# CITY OF ALBUQUERQUE

**RE: 1125 Snow Vista Blvd SW  
Grading & Drainage Plan  
Engineer's Stamp Date: 12/12/2025  
Hydrology File: M09D036  
Case # HYDR-2025-00447**

Based upon the information provided in your submittal received 2/03/2026, the Grading & Drainage Plan **is not approved** for Demo Permit, Grading Permit, or Building Permit. The following comments need to be addressed for approval of the above referenced project.

SITE GRADING PLAN

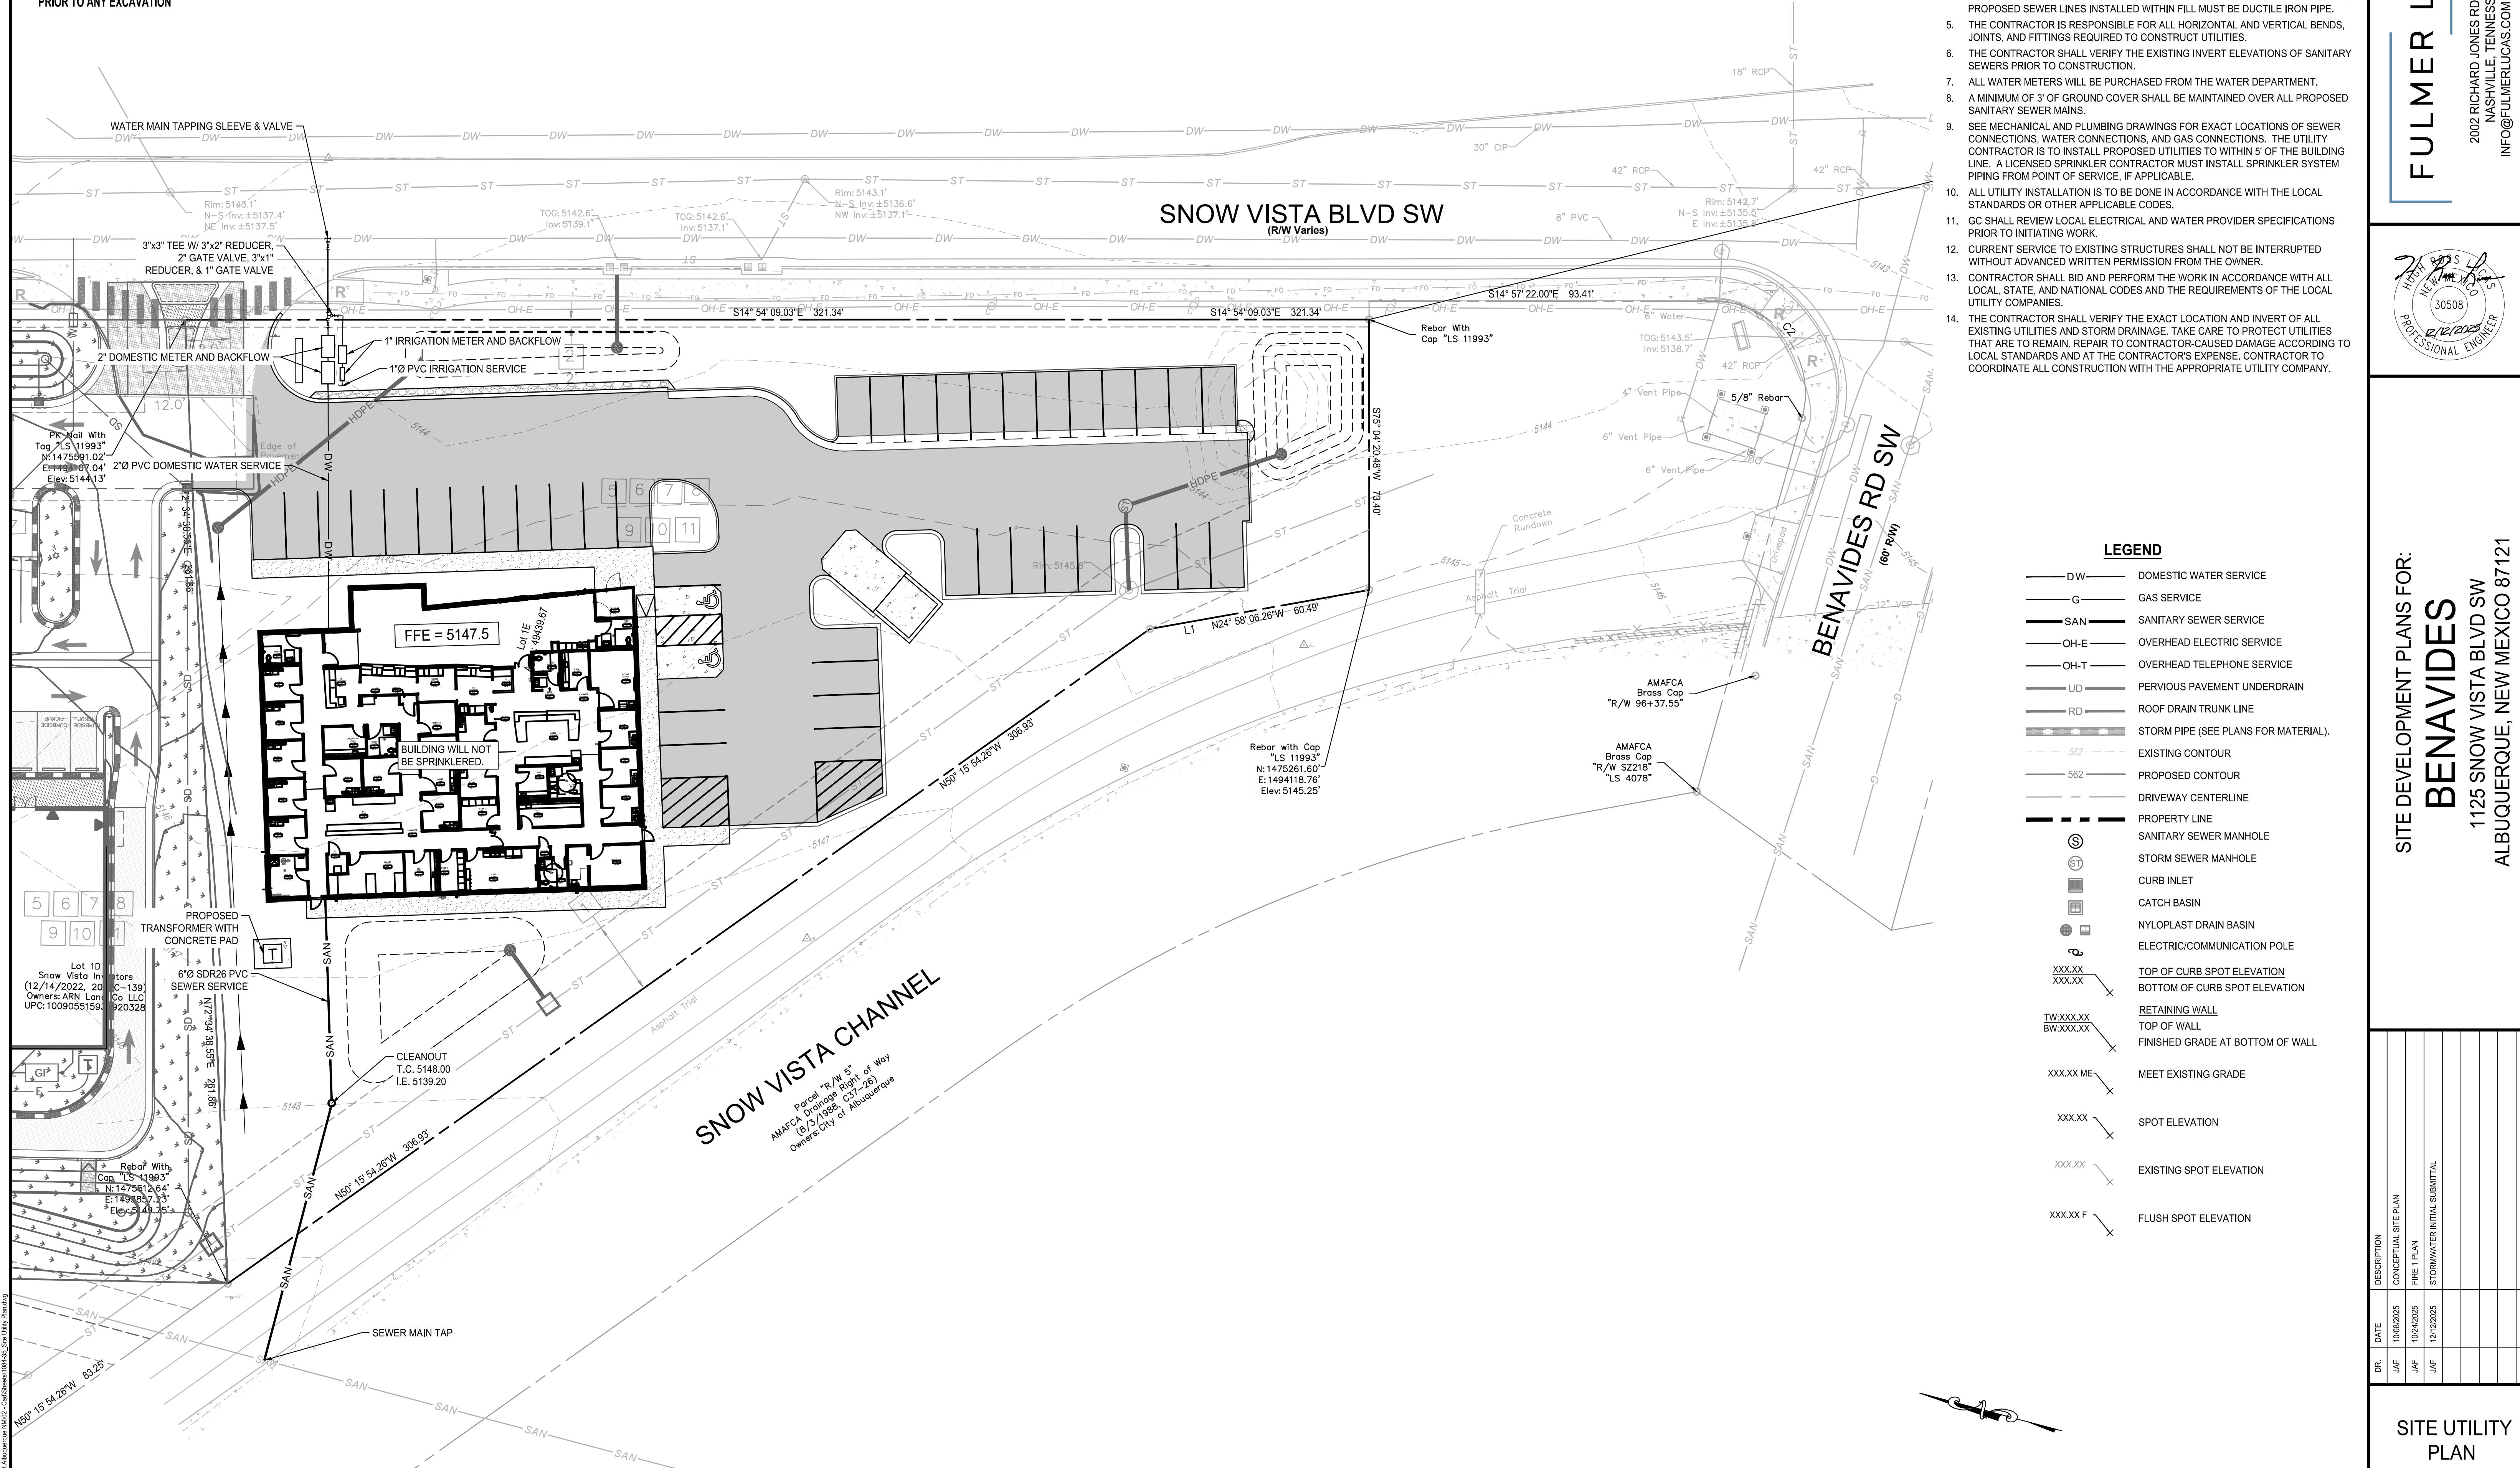
1. Stormwater discharges across the sidewalk are not allowed on collector roads and above; provide sidewalk culverts or drain lines through the curb.
2. Please reference City of Albuquerque standard detail No. 2236 – Sidewalk Culvert with Steel Plate Top at the sidewalk culvert.
3. An SO-19 Permit will be required and should be included on the request. Please include the [standard SO-19](#) notes on the grading plan. (This is for the sidewalk culvert)
